Application No: BN/43/21/HH
Site Address: 25 Skylark Way Barnham PO22 0FA
Description of works: Extension to garage and redesign roof.

Thank you for your internet representation made on 6th May 2021 which has been recorded as an objection with the comments as follows:

Elevations

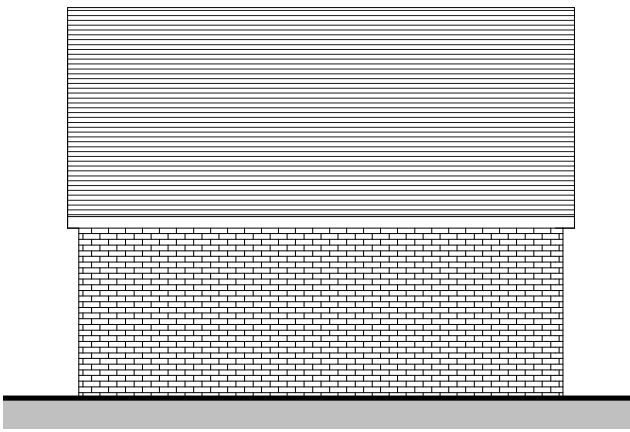
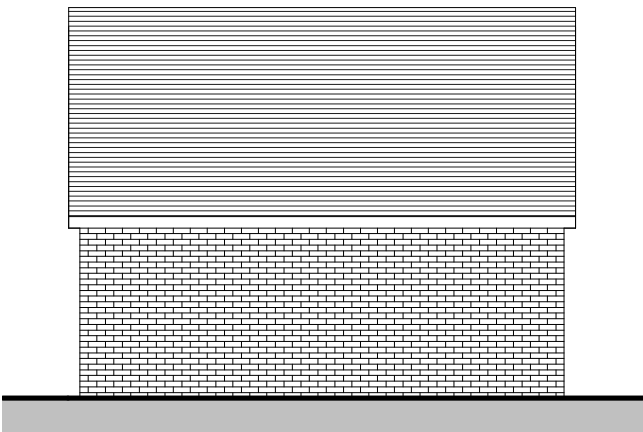
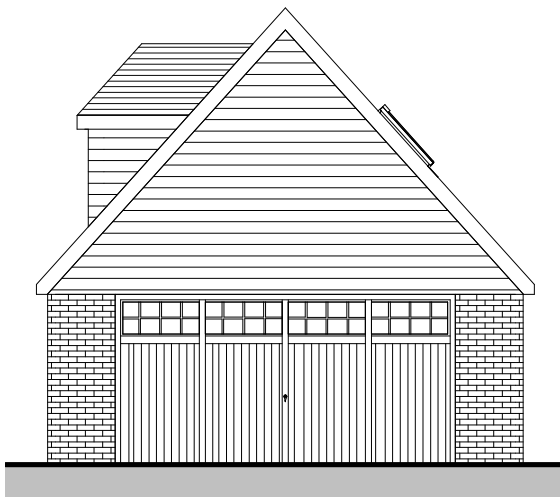
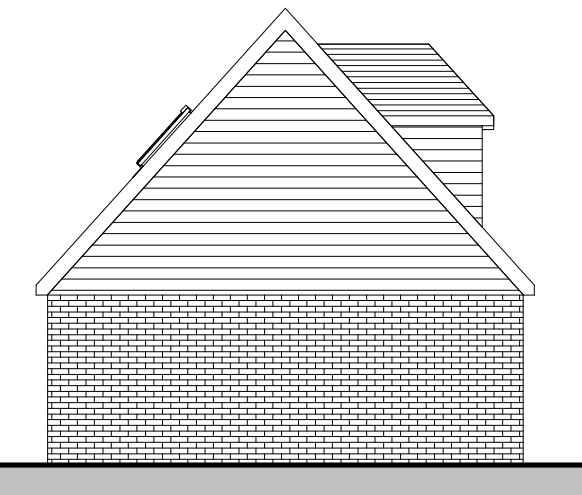
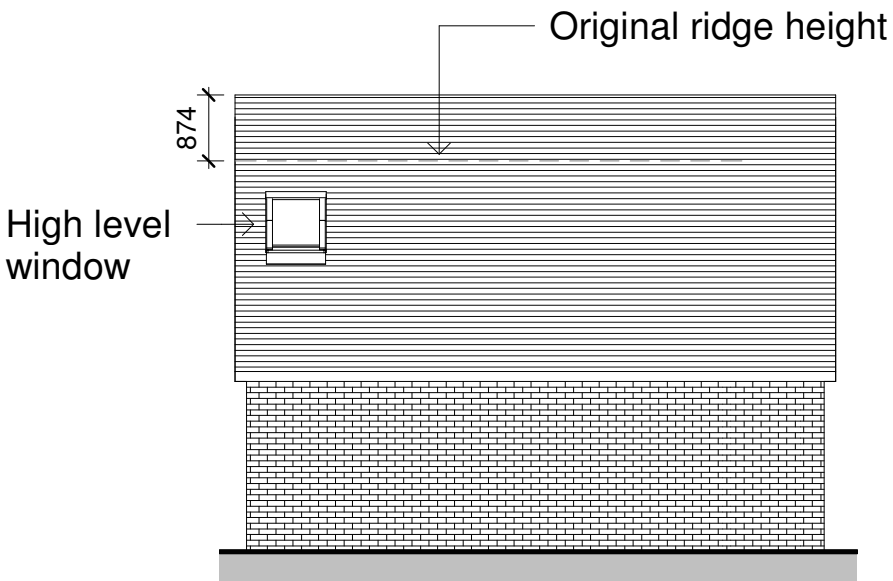
1. The increase of the garage roof ridge height and the addition of dormer windows on the north side (street facing) is not in keeping with the size, design or appearance of other garages in the street or on other houses on the development.

Proposed North Elevation

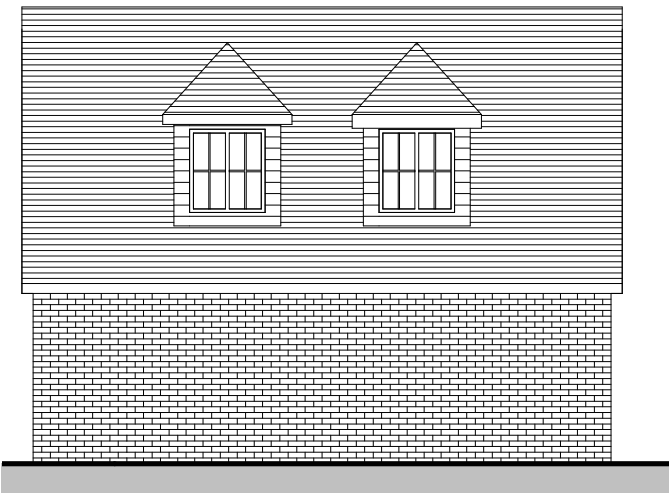
2. Both sides of the garage front elevation are visible from the street. The dormer window being proposed on one side only will look very unbalanced visually when viewed from the front.

Velux windows on both sides might be considered as a better option that is more in keeping with the character of the street.
